TIERRA WEST, LLC

April 12, 2011

**RE: THE BOULDERS – PHASE 1 SUBDIVISION
DRAINAGE REPORT AND GRADING AND DRAINAGE PLAN
PROJECT #1002632
ZONE ATLAS PAGE B-10 & B-11**

RONALD R. BOHANNON P.E. #7868	ENGINEER'S SEAL	THE BOULDERS PHASE 1	DRAWN BY DY
		RETAINING WALLS	DATE 05-06-11
		TERRA WEST, LLC 5571 MIDWAY PARK PLACE NE ALBUQUERQUE, NM 87109 (505)858-3100 terrawestllc.com	2011005-SH01-02- GRE-PH1
			SHEET # 3 OF 20 3 BOULDER SECTION JOB # 2011005

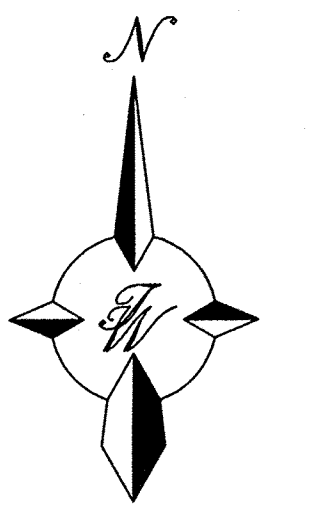
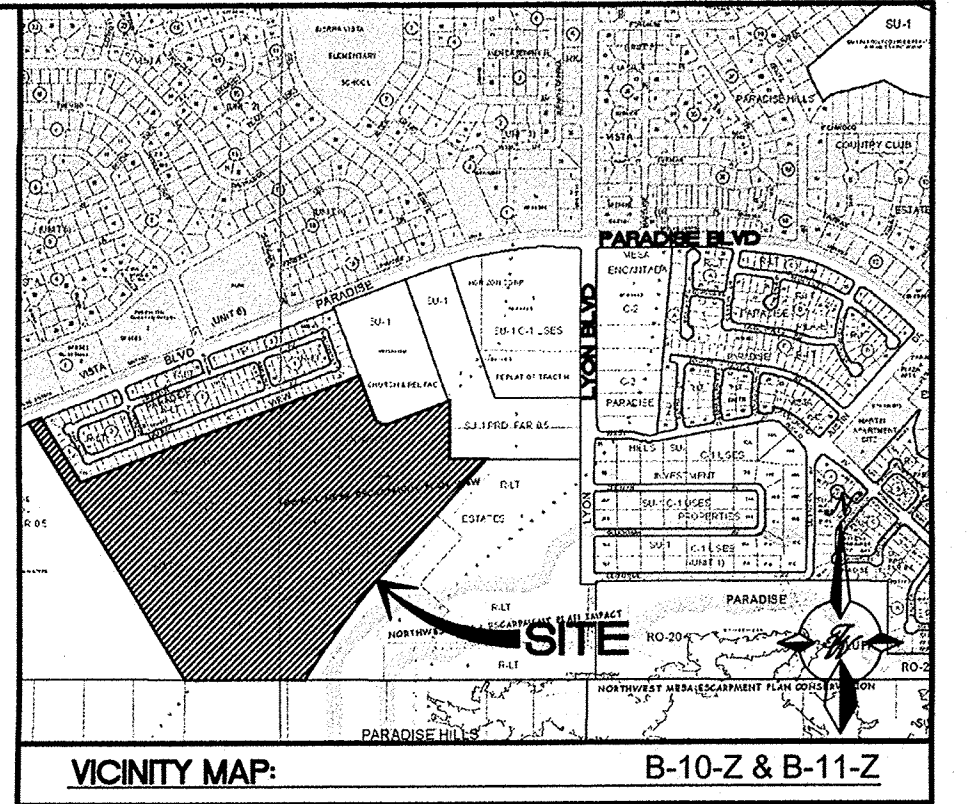
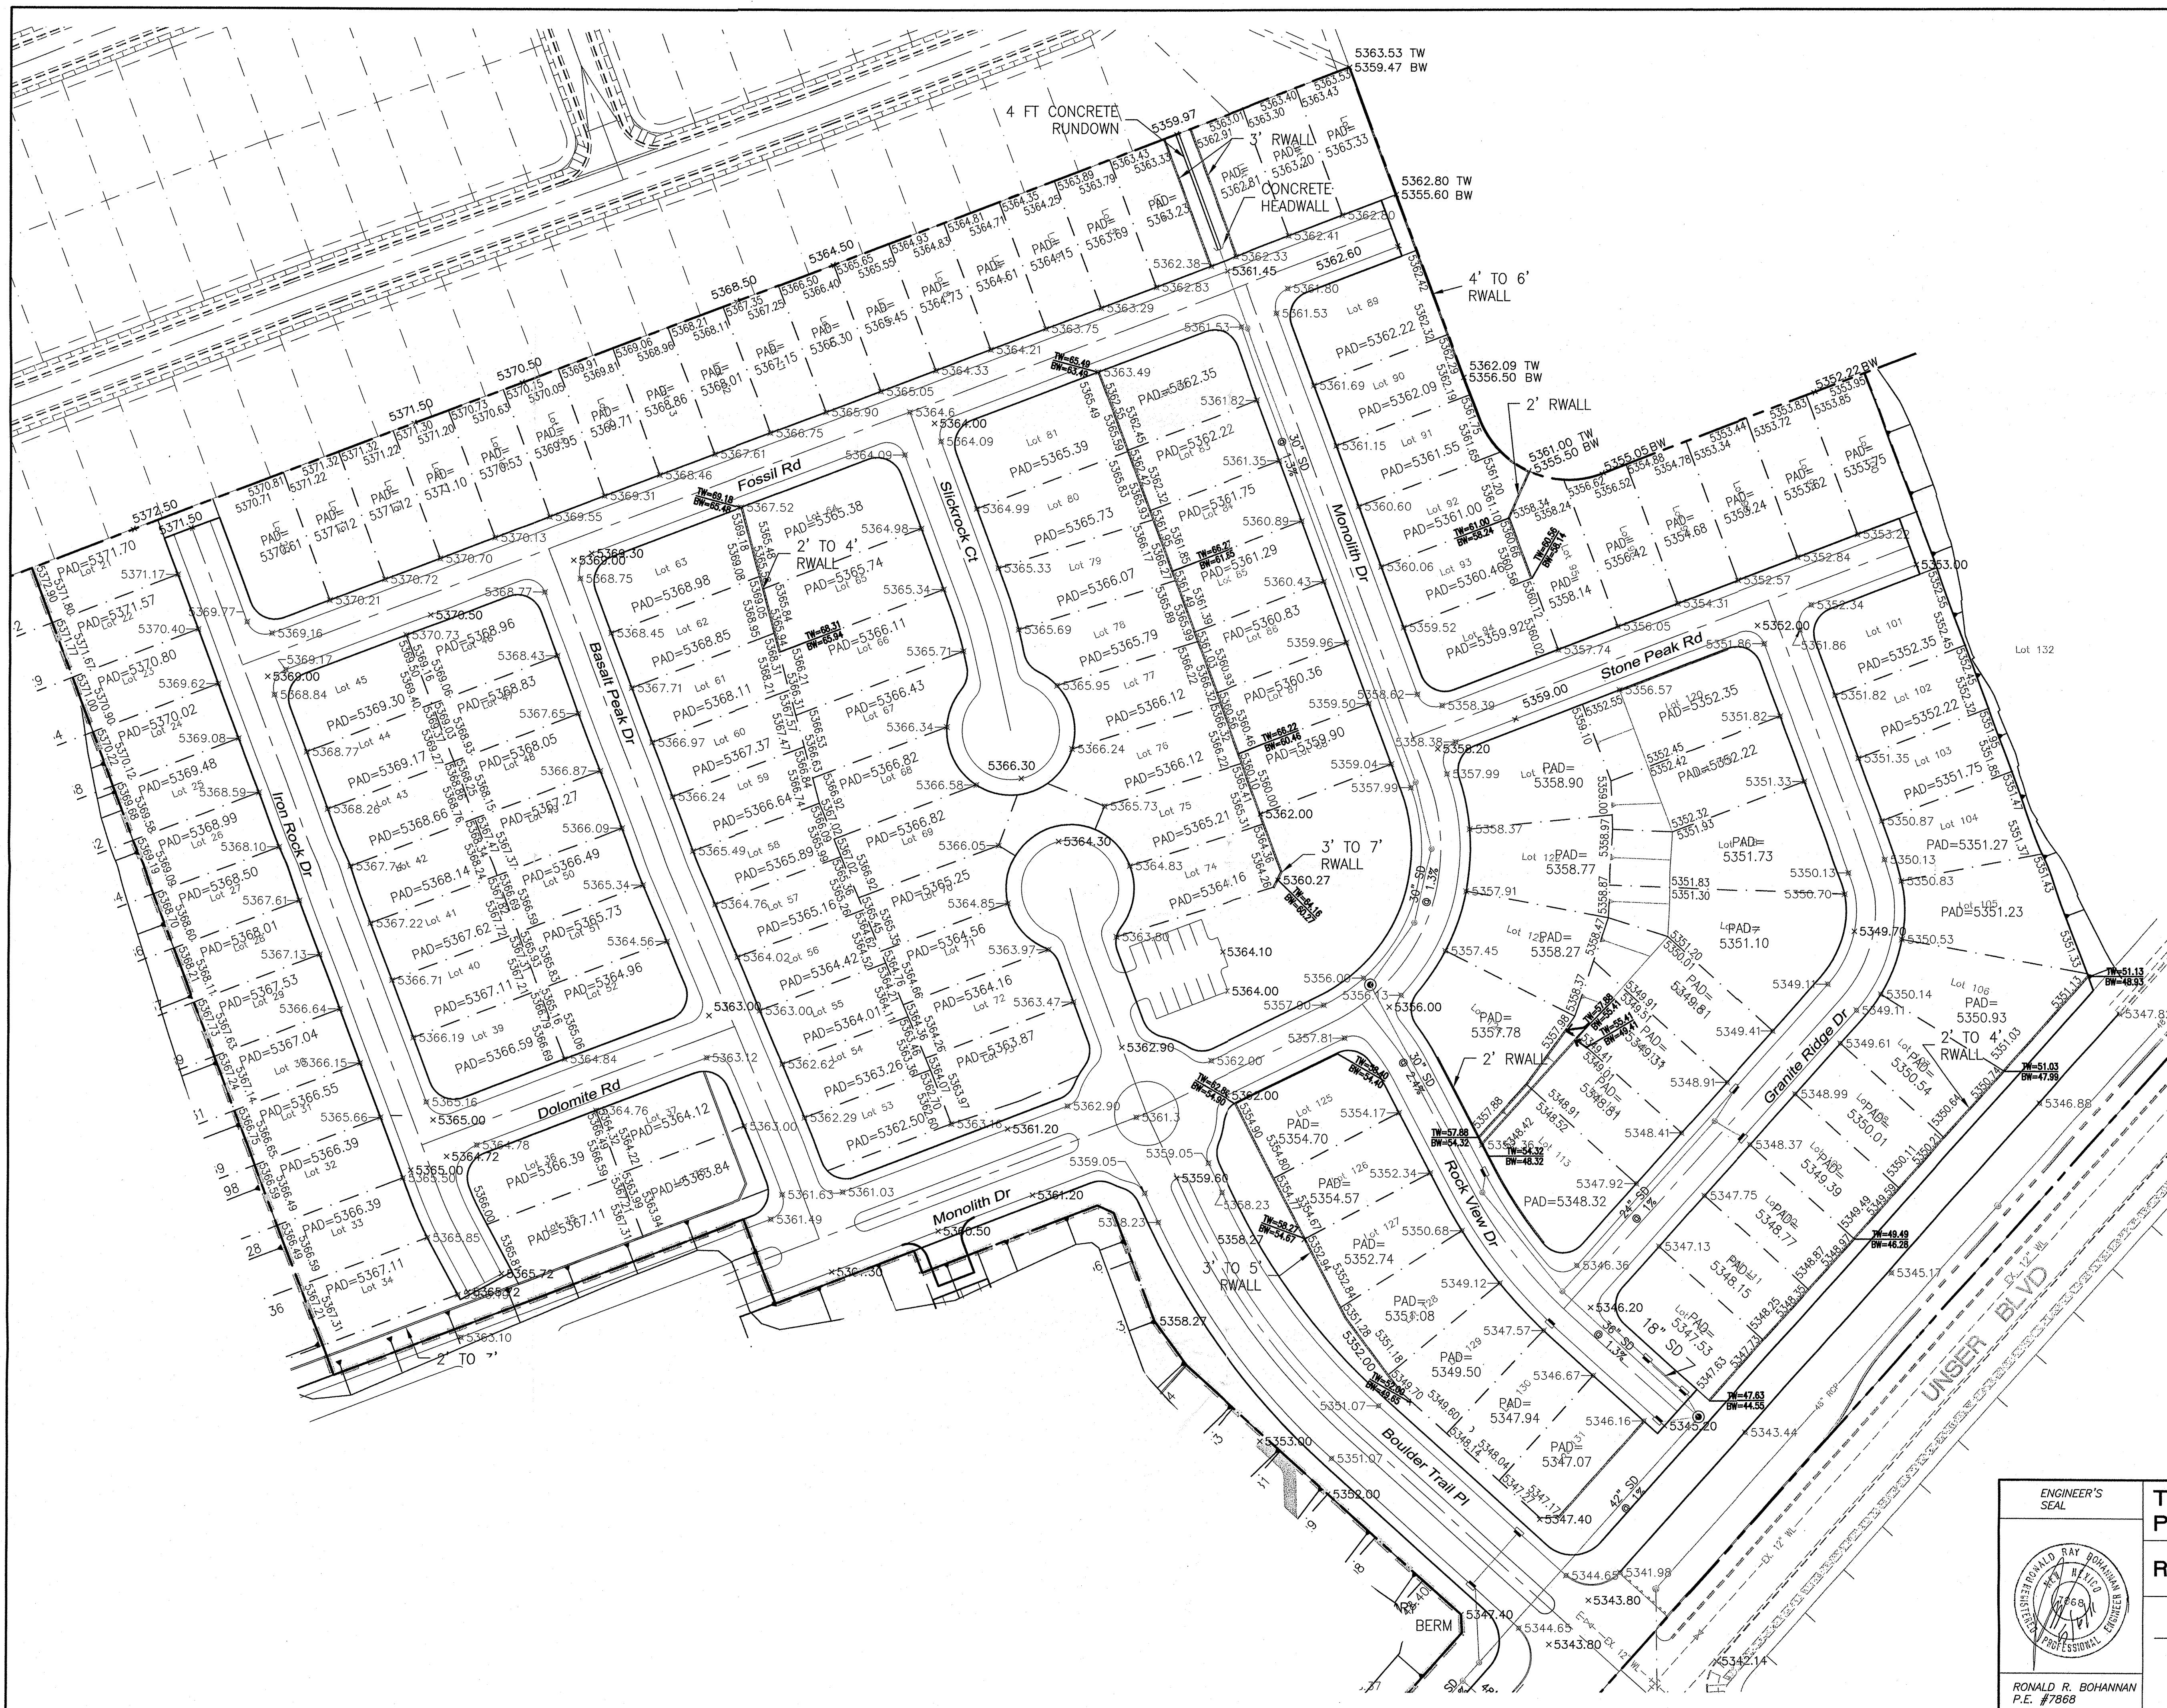
15. Your retaining wall line work should match the legend.

The line work was corrected to match the legend.

THE BOULDERS PHASE 1 GRADING AND DRAINAGE PLAN	DRAWN BY DY
		DATE 05-06-11
	TIERRA WEST, LLC 5571 MIDWAY PARK PLACE NE ALBUQUERQUE, NM 87109 (505)856-3100 tierrawestllc.com	2011005-SH01-02- GRE-PH1
		SHEET # 7 JUN 14 2012

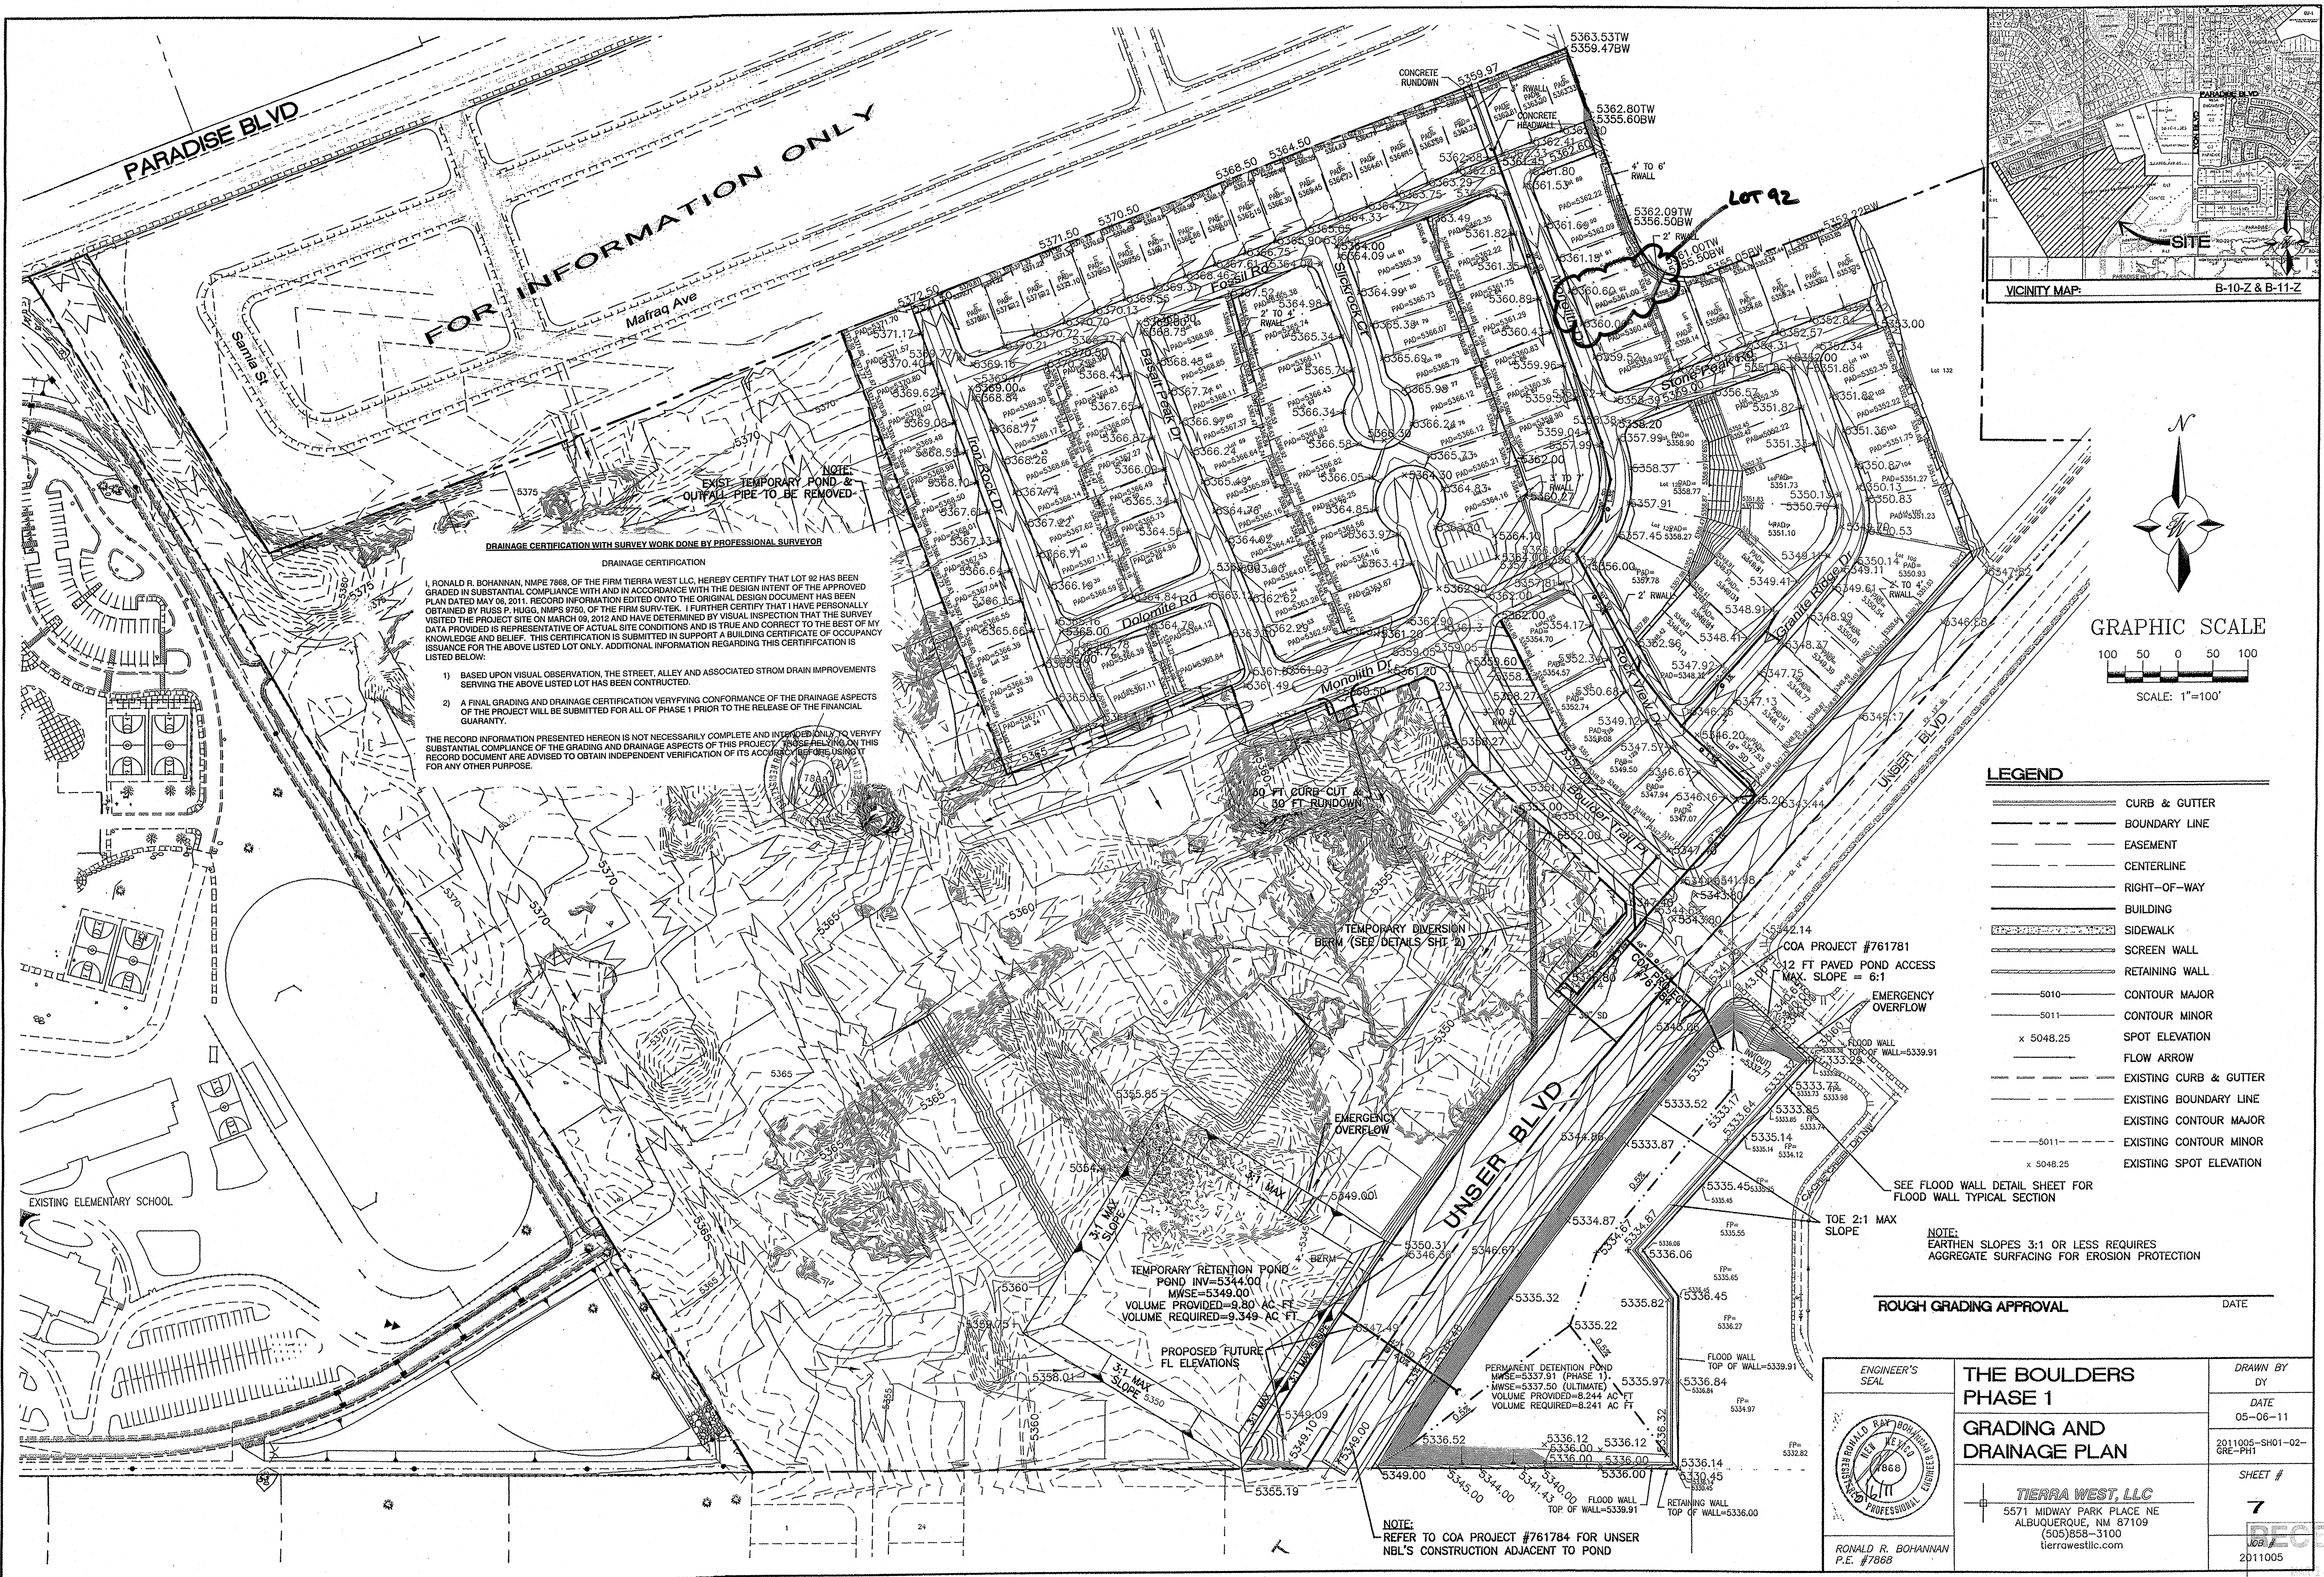
7. Provide the Volume Required, Volume Provided and Water Surface Elevation for the Unser Pond for Phase I on the grading plan and for all three phases in the drainage report.

11. The Volume Calculation table in the report shows the WSE at 5343 for 22.5 ac-ft. Finished Floor elevations east of the pond are around 5334 to 5346. It is not desirable to perch water 9 feet above adjoining houses.

Phase I volume and WSE was added to the grading plan and for all 3 phases in the drainage report.

The top of pond elevation is 5340 for Phase I and for the ultimate conditions. The MWSE for Phase One is 5337.12. The MWSE under ultimate conditions is 5337.46. Both are listed on the grading plan. The pond volume calculation table was corrected to reflect this.

8. It appears some grading will be necessary offsite west of the furthest northwest lots of Phase 1.

Slope ties at 3:1 maximum grades are shown where this occurs.

6. Provide flow line elevations or a profile for Unser Blvd fronting this development.
Proposed flow line elevations were added to the grading plan for the future

section of Unser that fronts Phase I. This portion of Unser will be deferred to be designed and constructed when required.
